Application no: **3/2021/0303**

Address: **1 Wildmans Barn Longsight Road Langho BB6 8AD**

Proposal: **Proposed external works, including shed, timber gazebo and stone wall with timber entrance gates.**

The Local Highway Authority have viewed the plans and highway related documents and have the following comments to make:

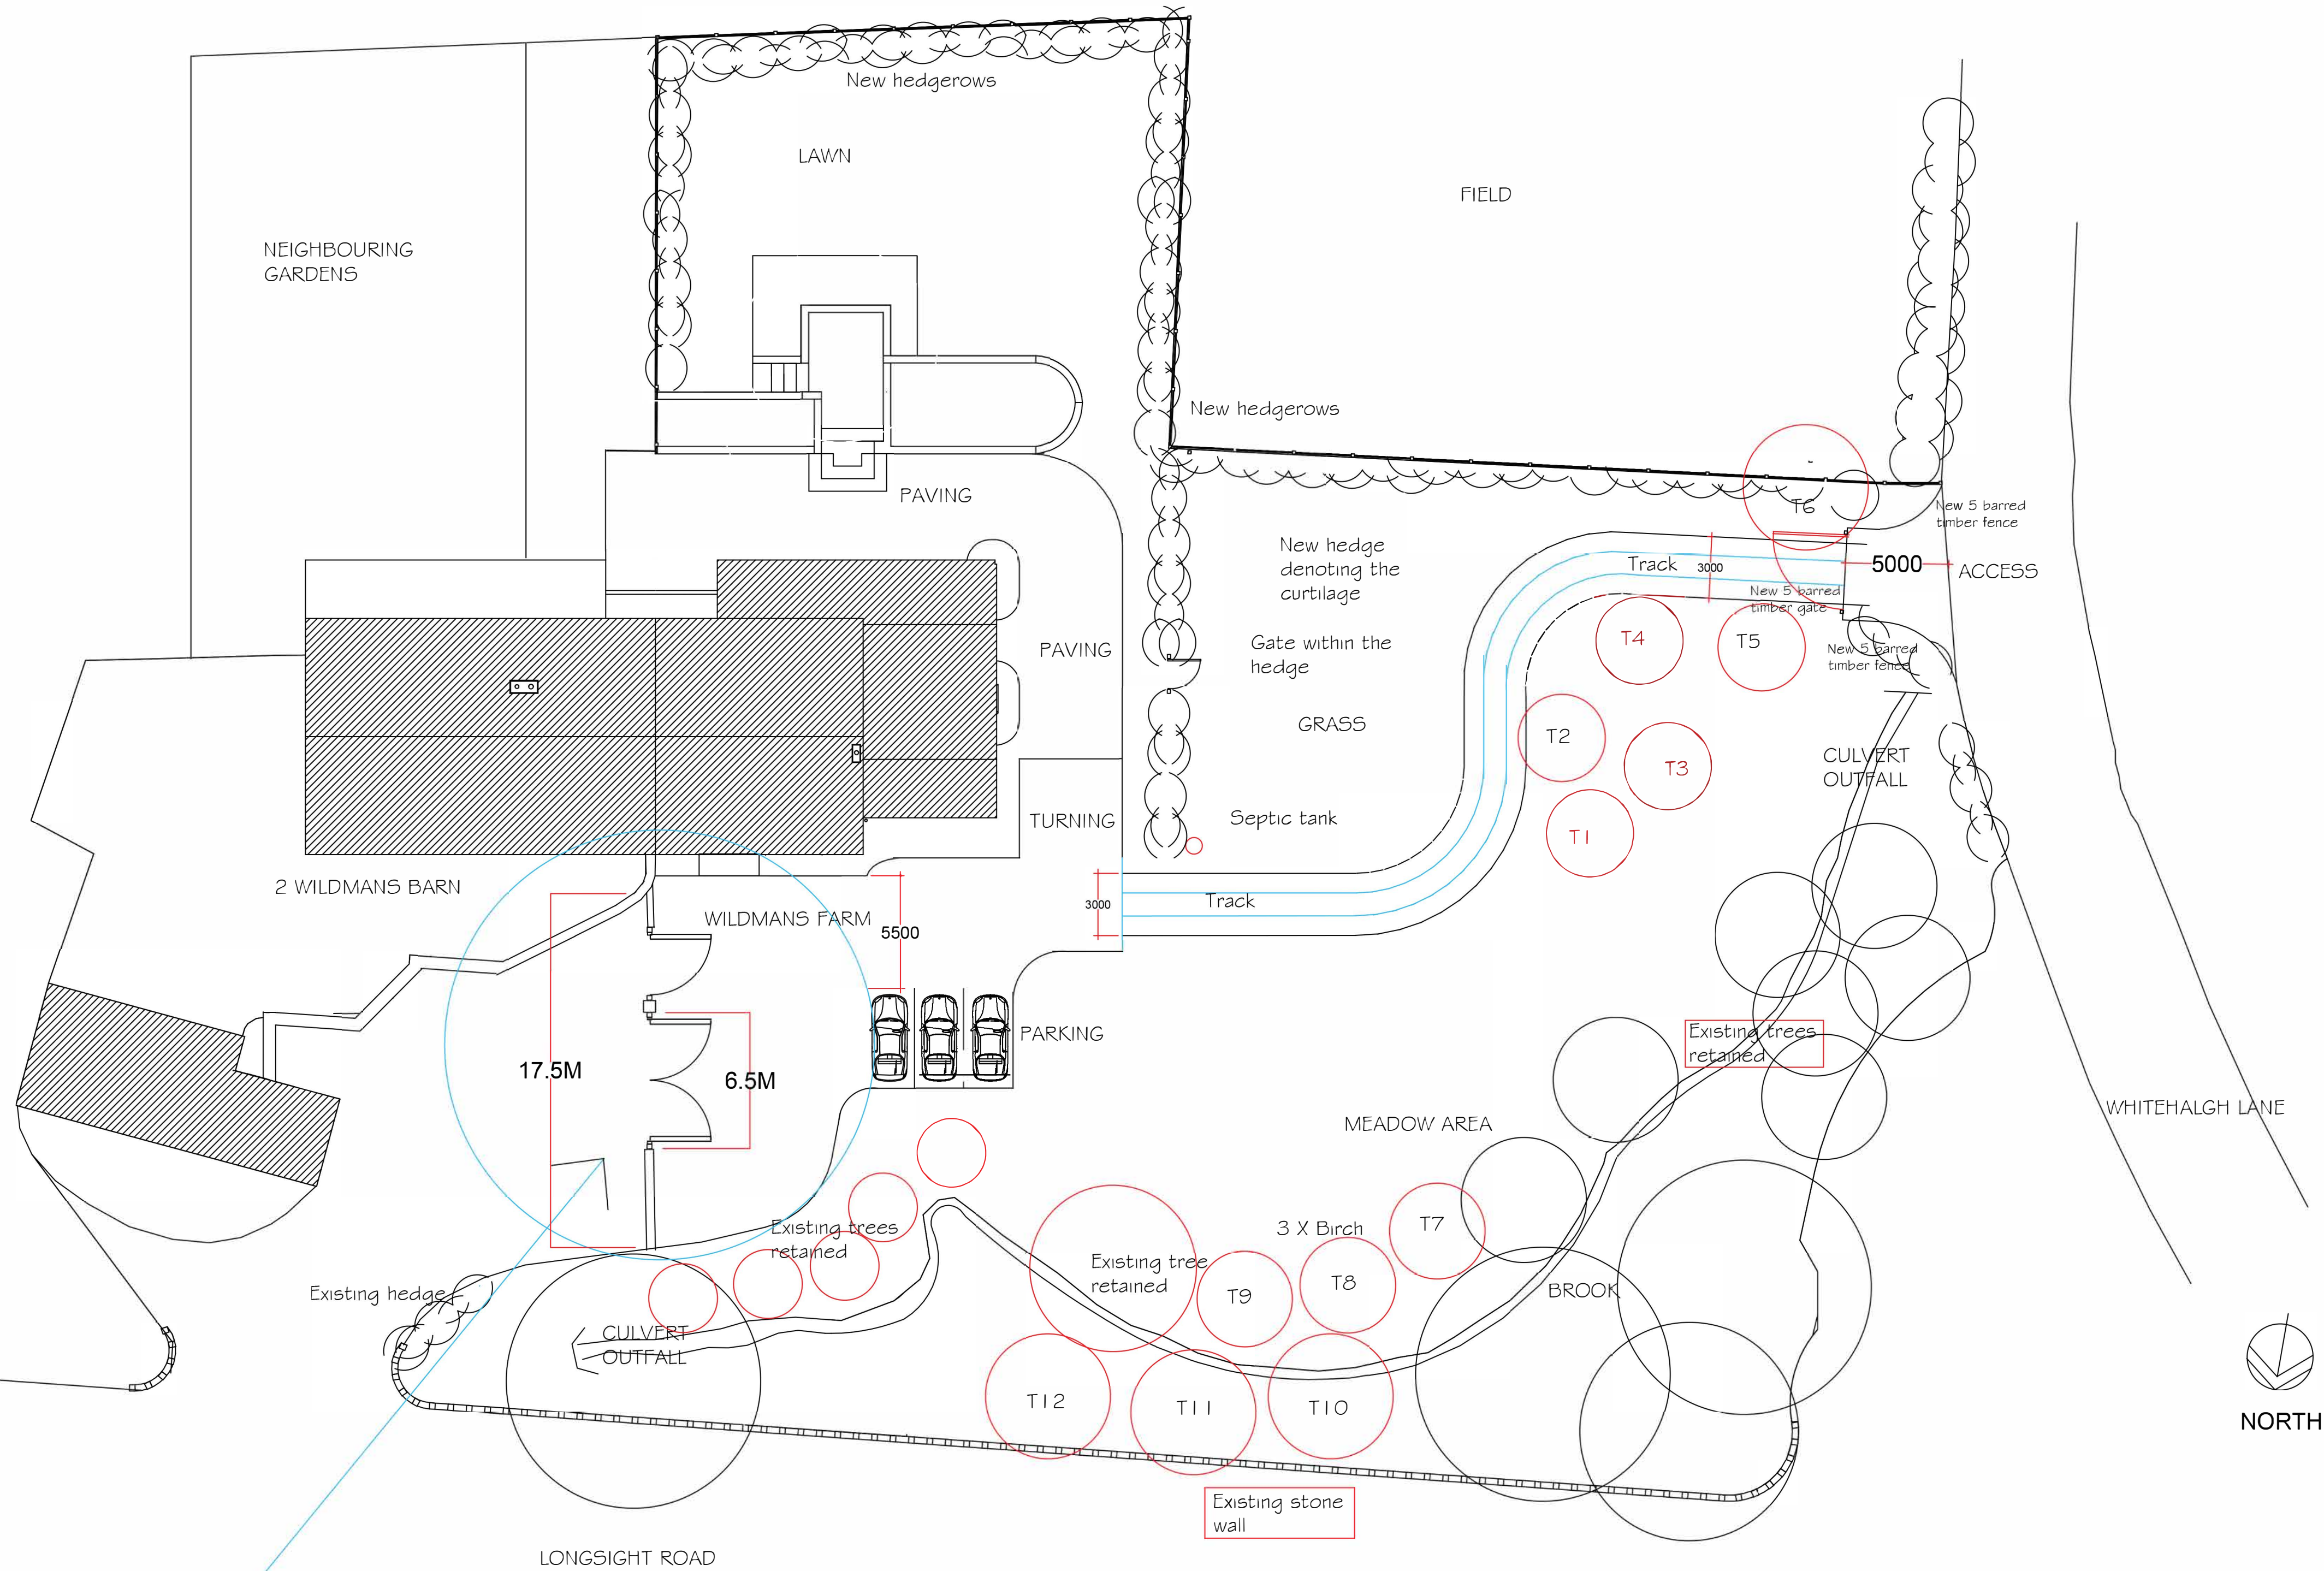
These alterations are shown on the drawing titled "Proposed Site Plan" drawing number 1000. The proposed site access from Whitehalgh Lane is approximately 4.65m wide and will be gated, which is set back a distance of 5m from the public highway. This complies with the local and national guidance.

1.No part of the development hereby permitted shall be occupied until such time as the access arrangements shown on Proposed Site Plan drawing number 1000 have been implemented in full.
